CITY OF ALBUQUERQUE

November 7, 2012

Re: Presbyterian Systems Office Drainage Management Plan and Grading and Drainage Plan, Engineer's Stamp dated 10-22-12 (B17/D003)

C-103
OF

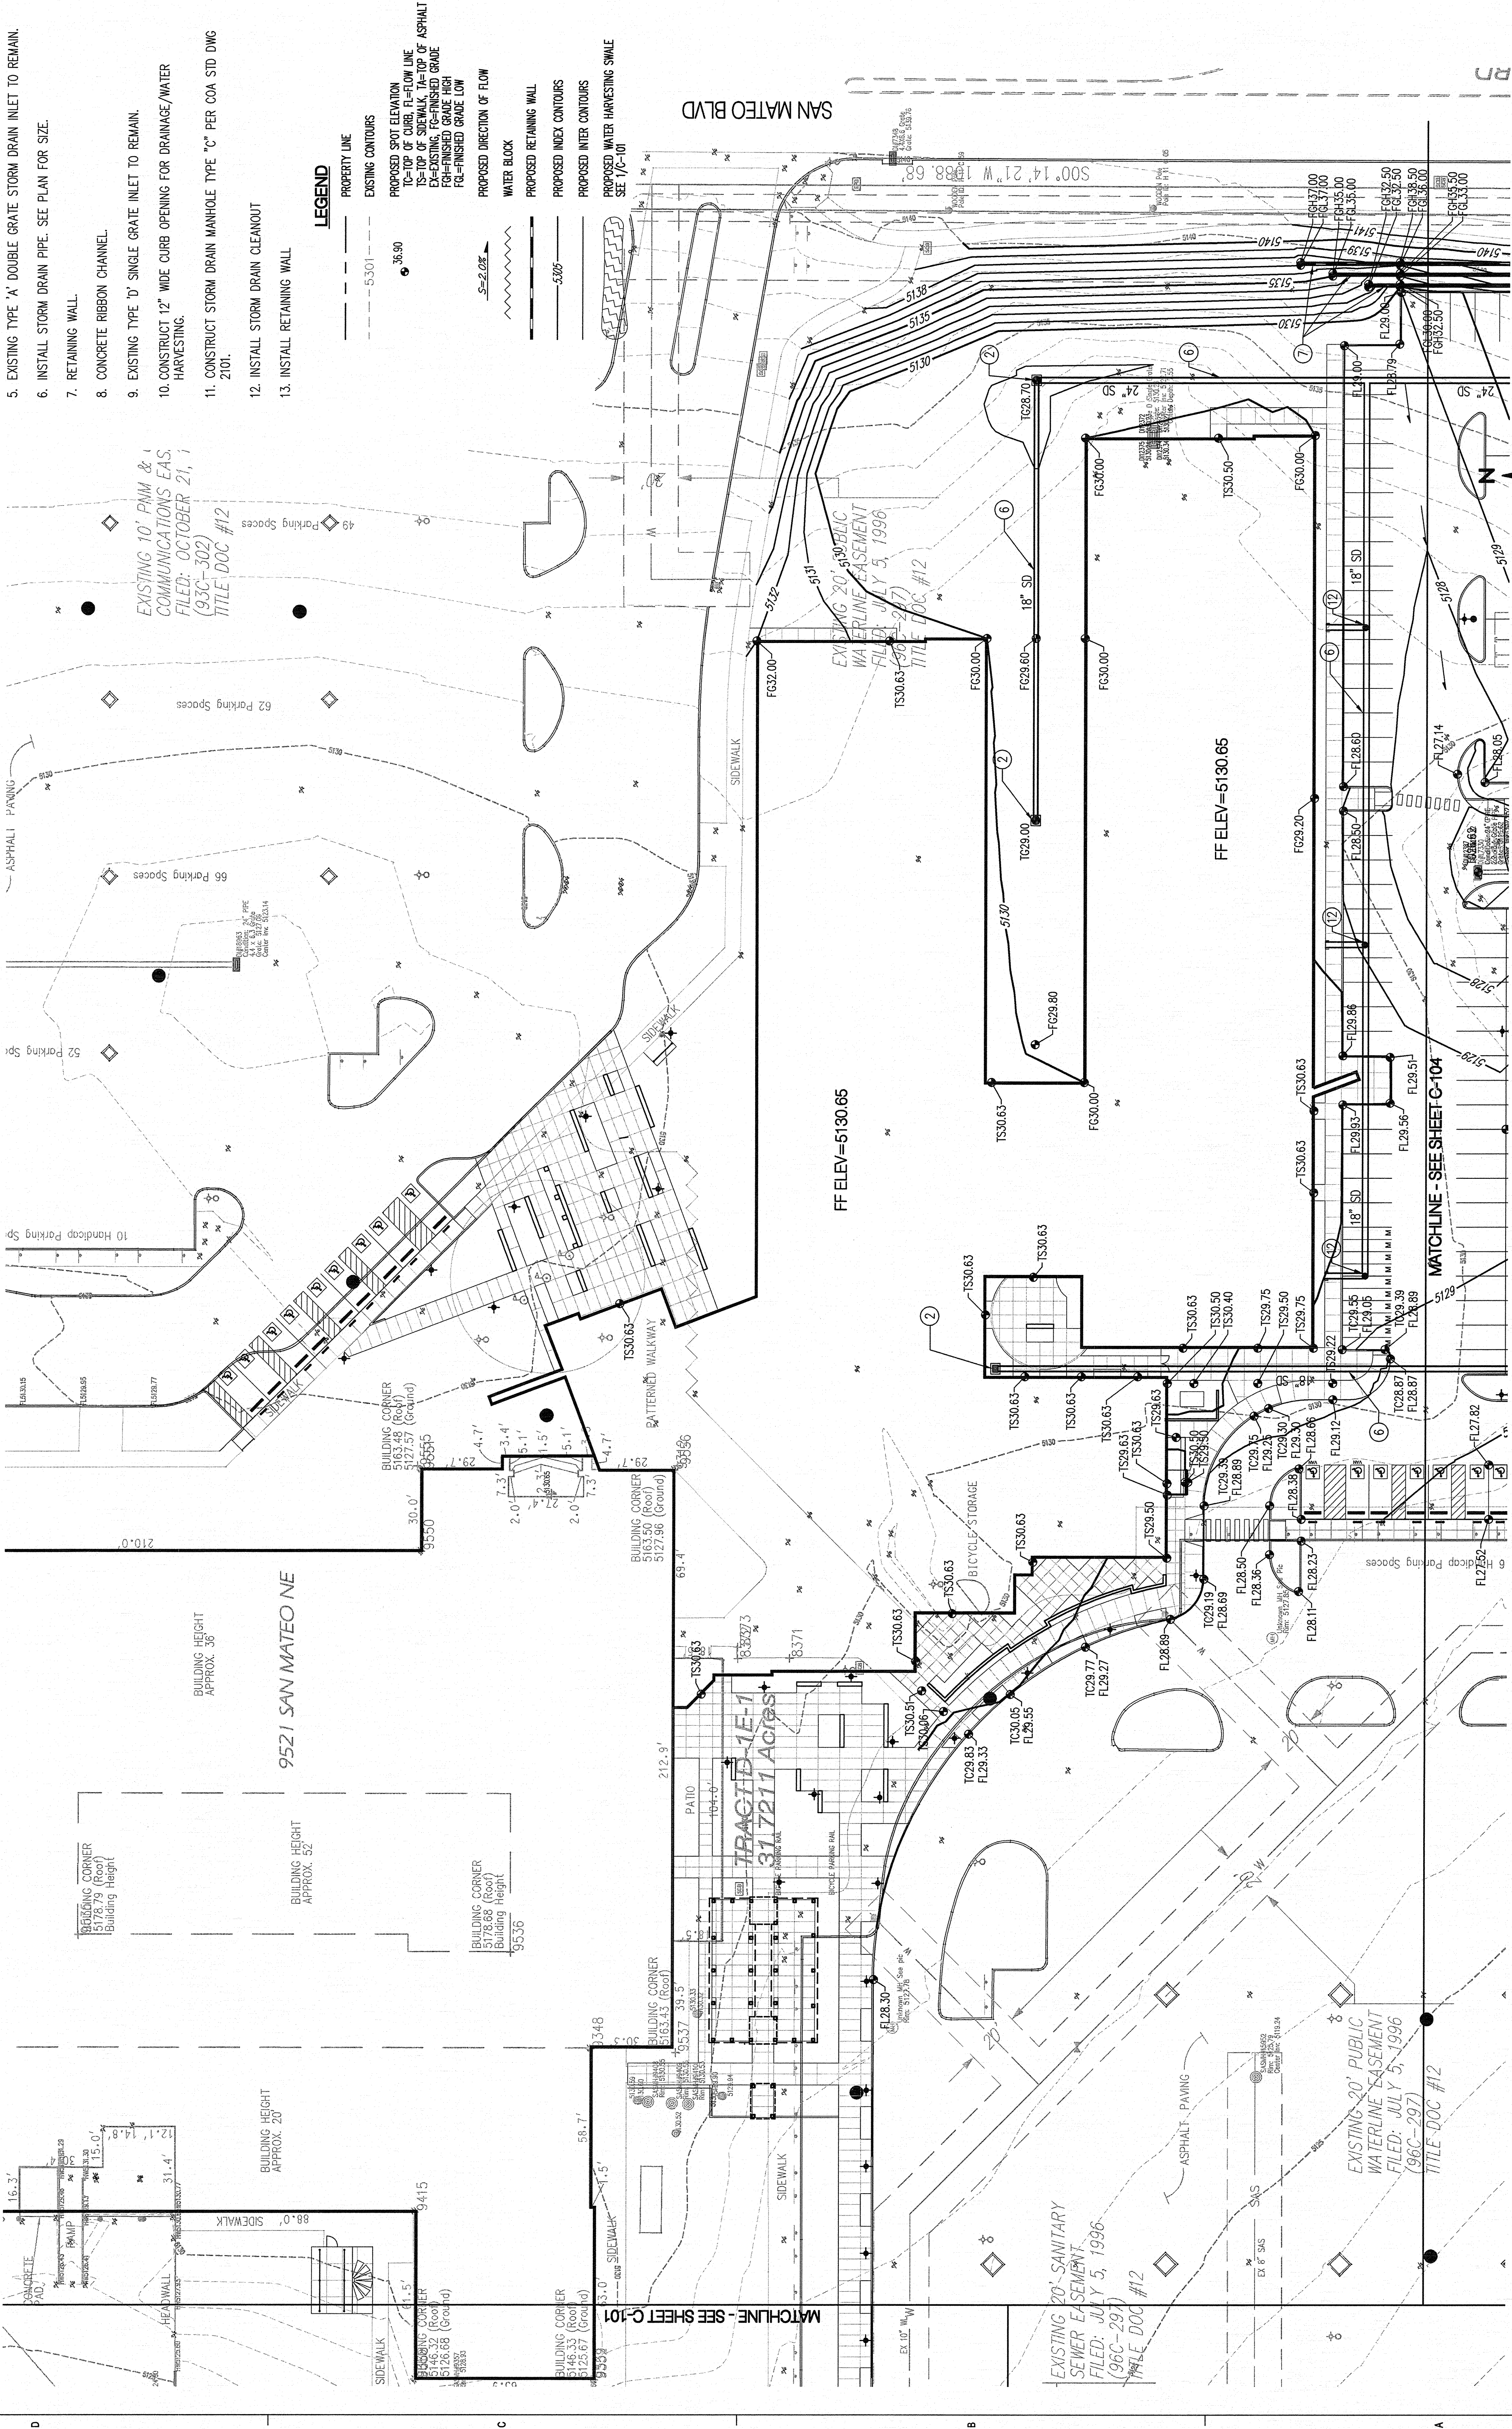
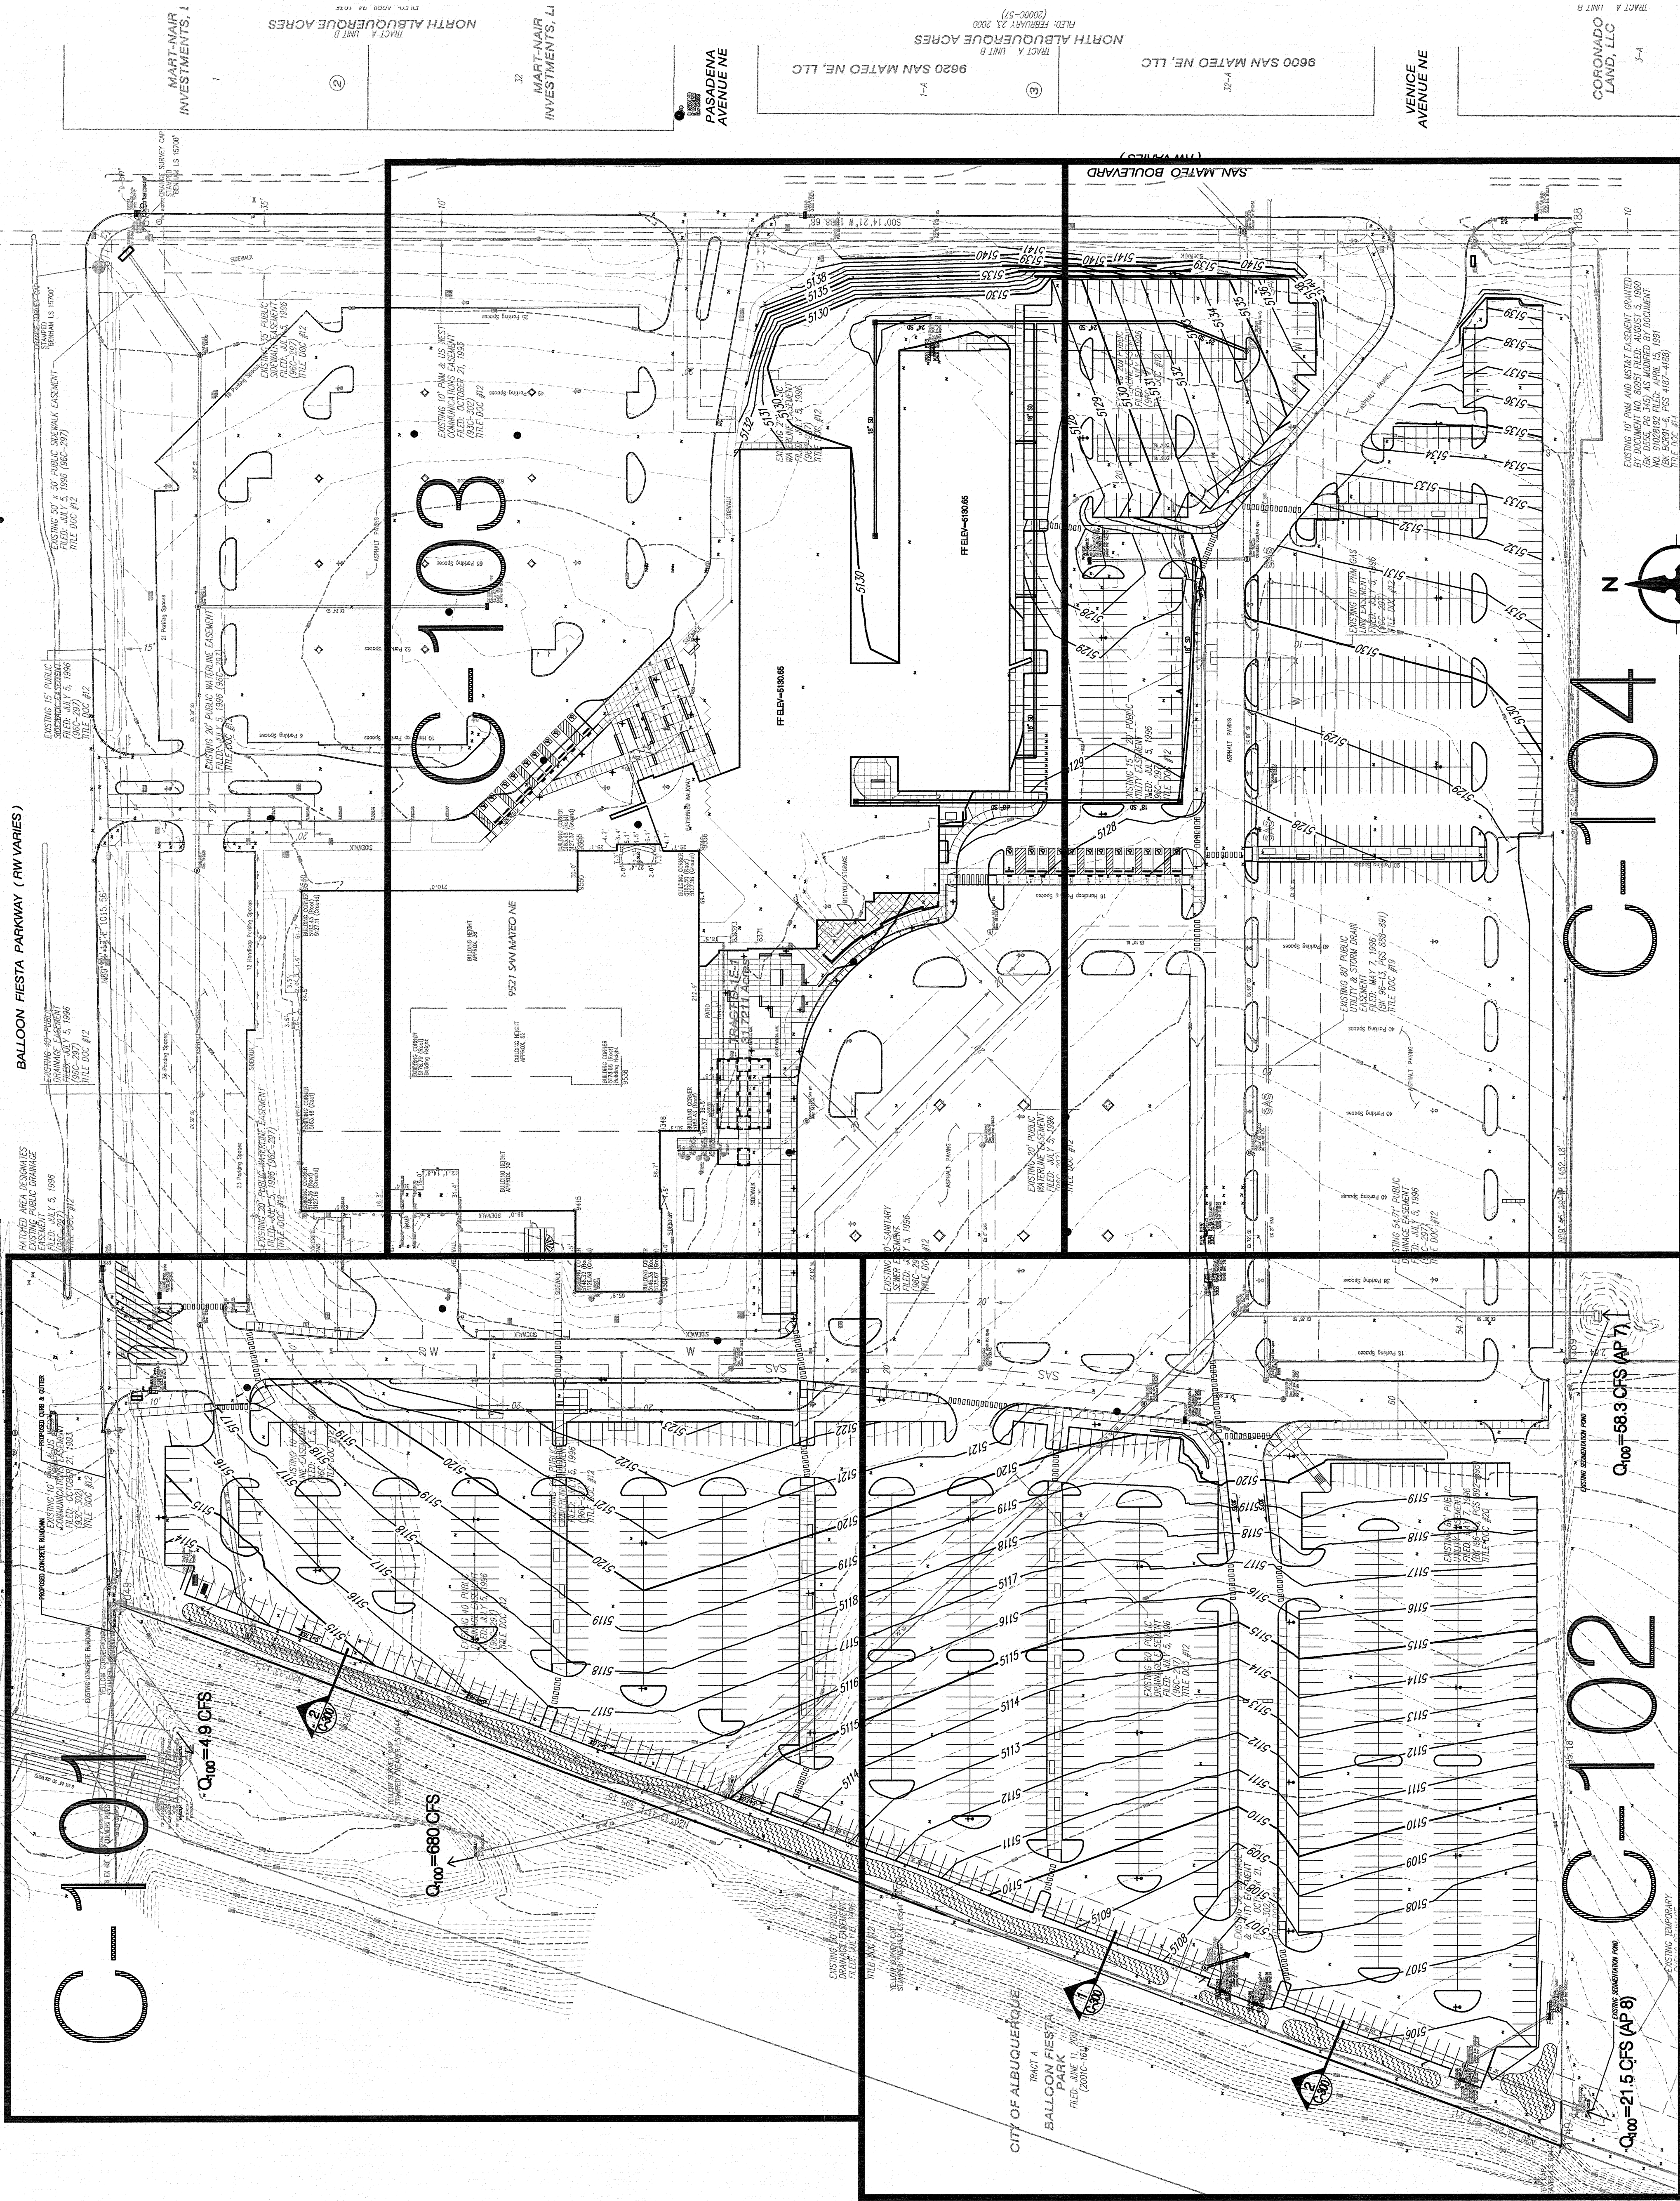
- Include the area to the north of Sheet C-103 with existing grades and storm drain structures.
- Please include a note that landscaping within the islands will be depressed where possible.
- Clearly show the inlet grades, inlet inverts, and storm drain pipes and sizes.

CITICORP DRAINAGE REPORT	
Project No.	ON-SITE DRAINAGE PLAN
Seal	PLATE 4
Job No. 96177A2417	Sheet 1 of 1
Drawn By: TONYM	Date: 3/96
Checked By: CWH	Scale: 1"=60'

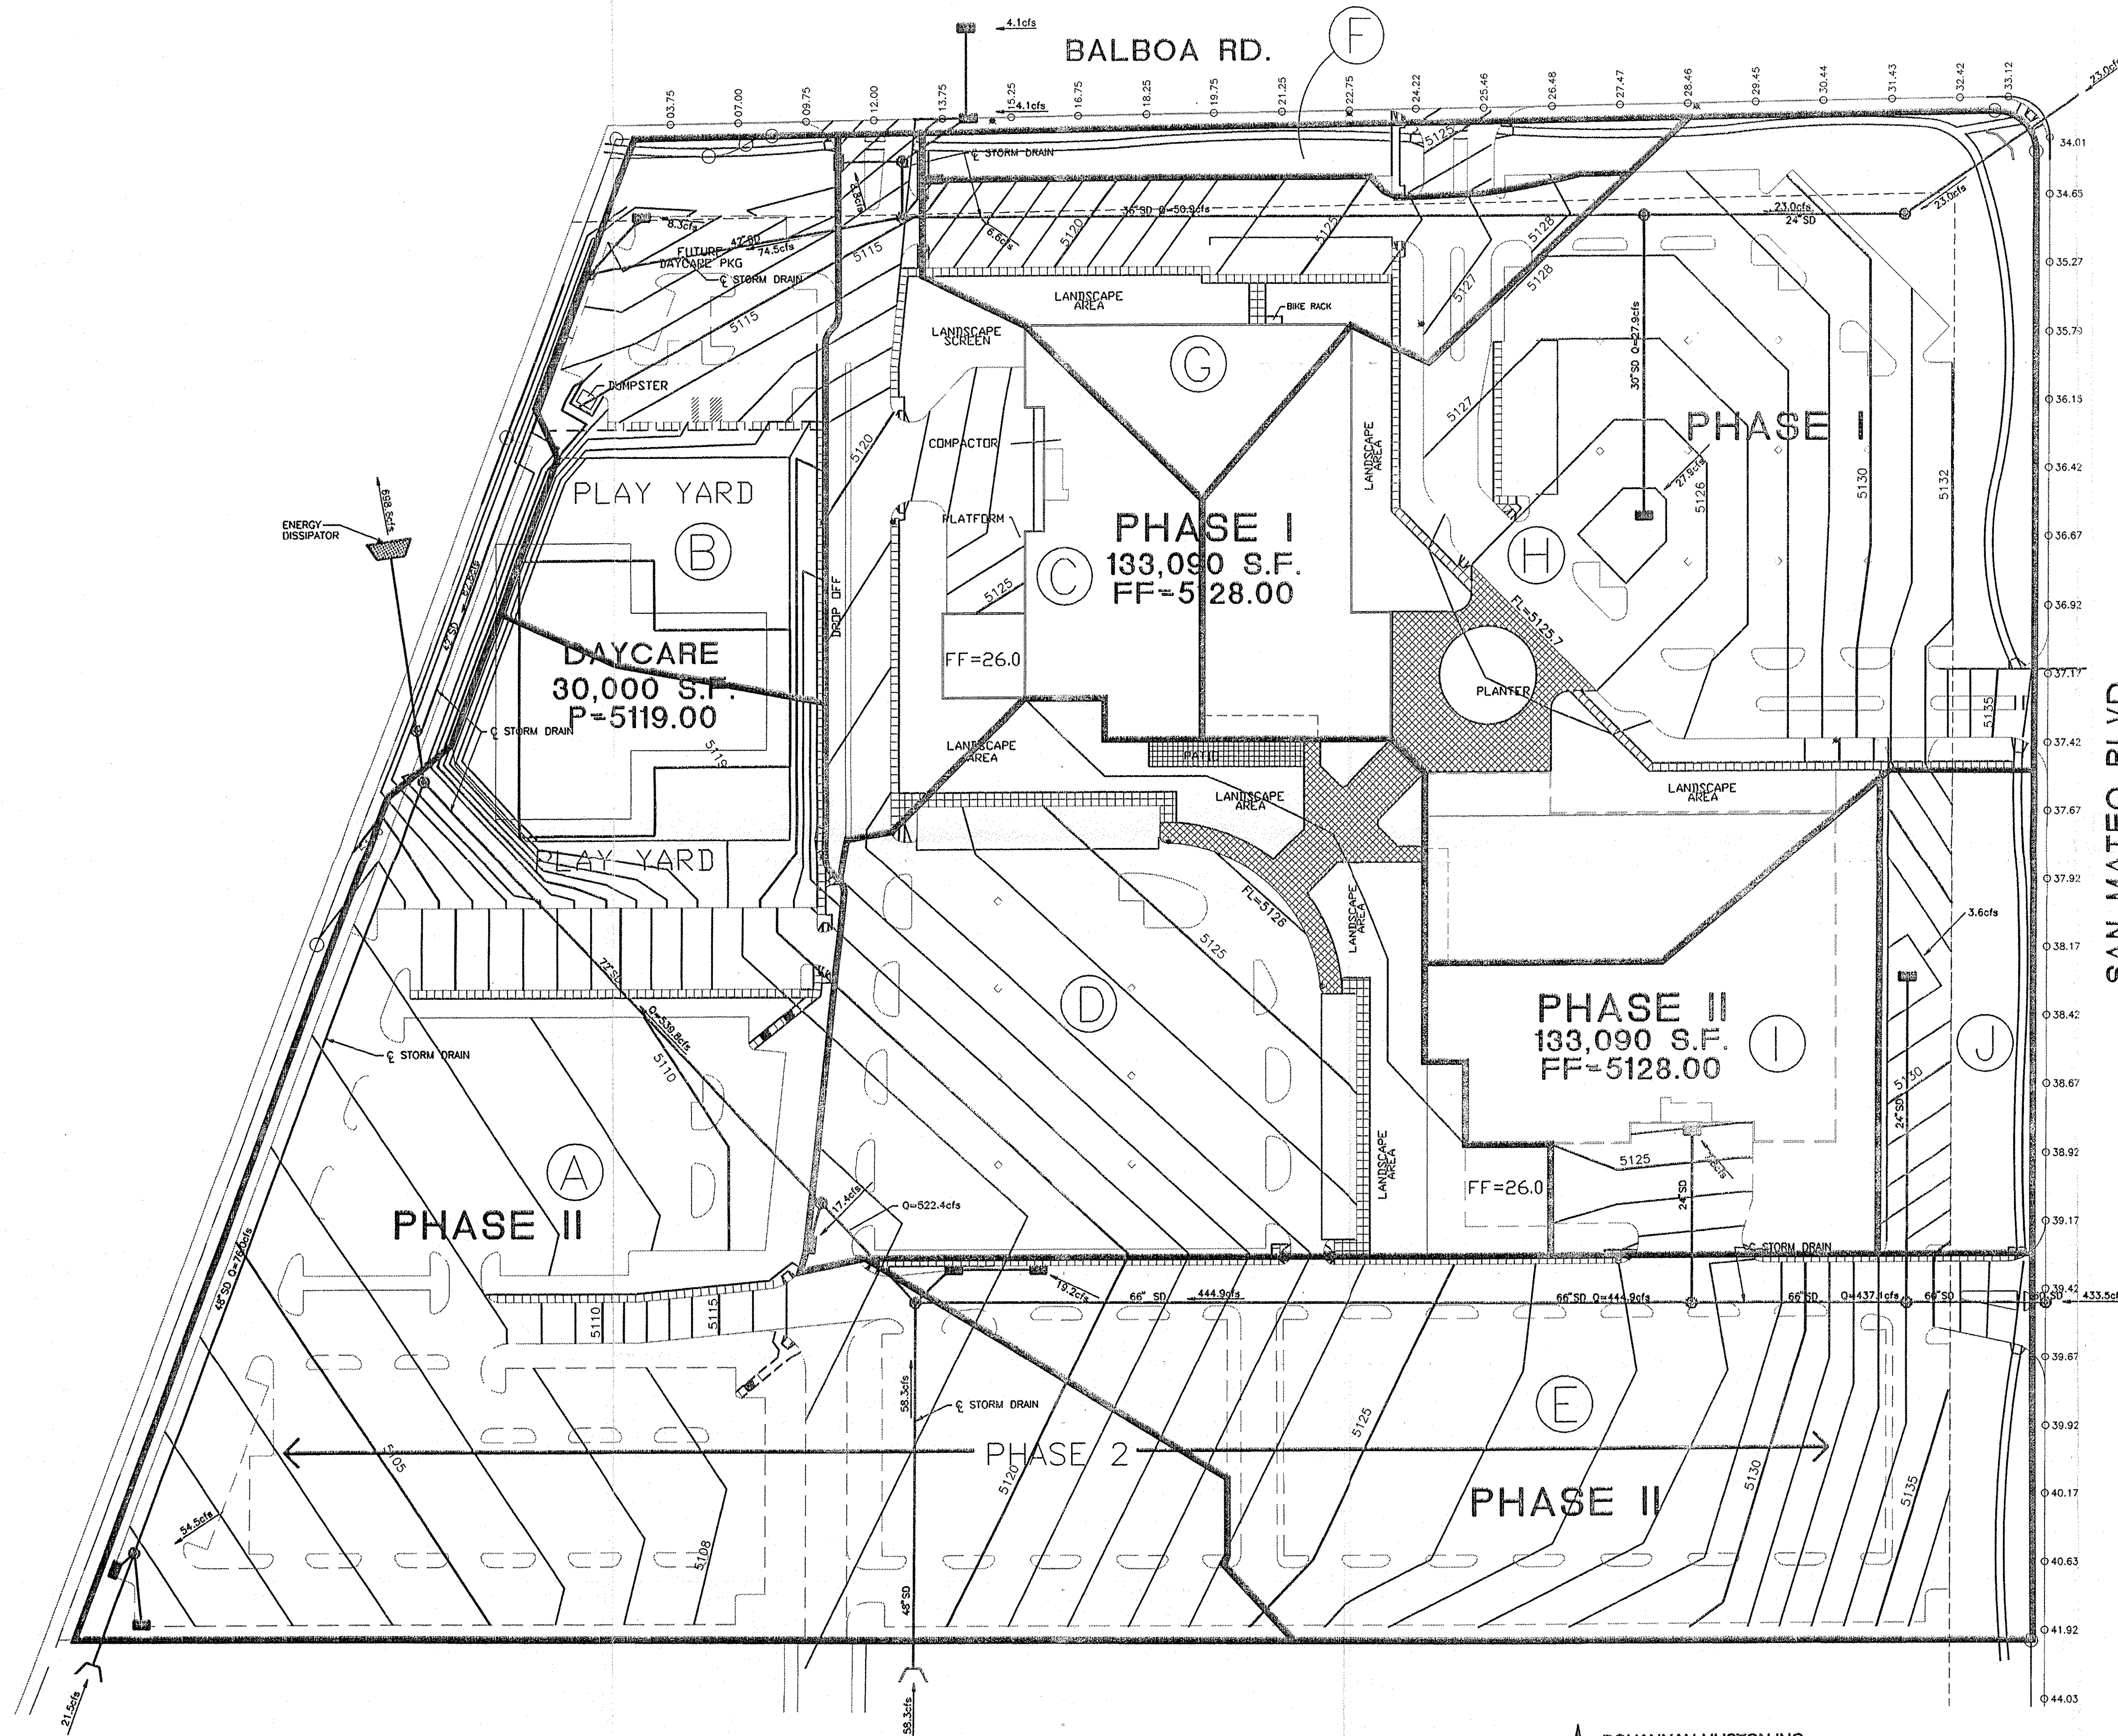
- Is there an existing inlet south of inlet IN-G1 that is being relocated?
- Inlet Table should include the actual water depth at the inlets. Any water depth exceeding +/-10" inches will flood the cars in the parking lot. Water depth at inlets IN-E1 and IN-J1 appear fairly high in the parking lot area. Inlet IN-J1 appears to have a maximum head of 2.68'.
- Was any clogging factor (typically 50%) used when calculating the inlet capacity calculations for the inlets in sump condition?
- Provide storm drain Pipe Capacity Table. Clearly show the pipes and sizes.
- There appear to be double lines where the islands are within Basins I and J.
